Christina Stacey - Re: Permit #1787 - 41 Christy Rd

From: Raffe Mooradian <iamjam@maine.rr.com>
To: Christina Stacey <cstacey@portlandmaine.gov>
Date: 9/21/2015 4:19 PM
Subject: Re: Permit #1787 - 41 Christy Rd

I am in the process of reviewing and approving your permit for front step replacement at the above-referenced address. Firstly, I wanted to apologize for the long delay in reviewing this permit. I appreciate your patience during this process.

Plot Plan

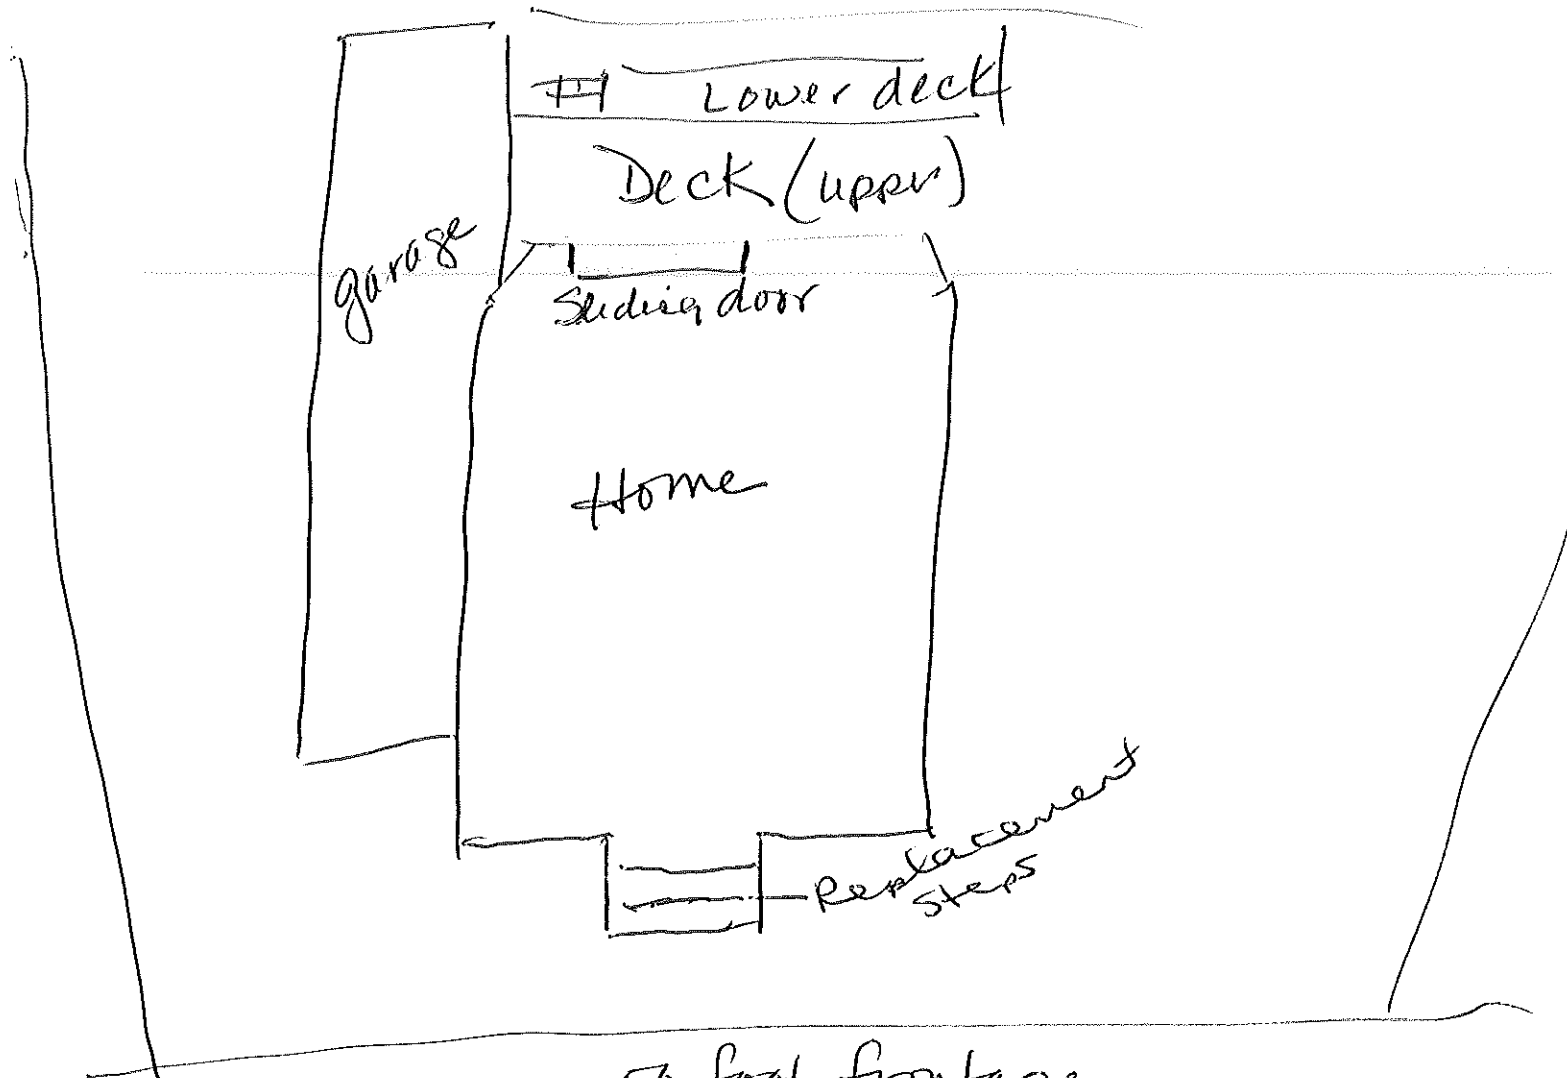
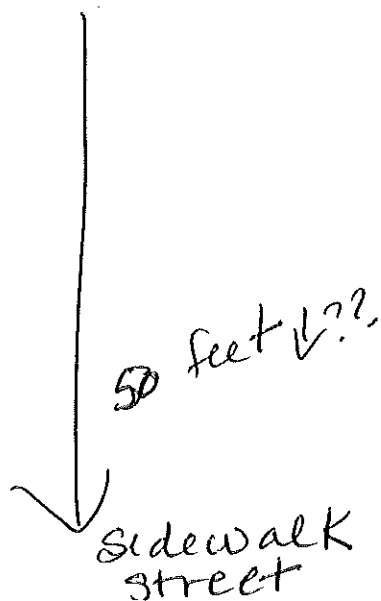
Before I sign off, I did have one quick question - can you just confirm that the replacement steps are the same footprint dimensions as the old ones? I assumed they were but there were no measurements included, so I wanted to double check.

Railings will go from top platform to last step
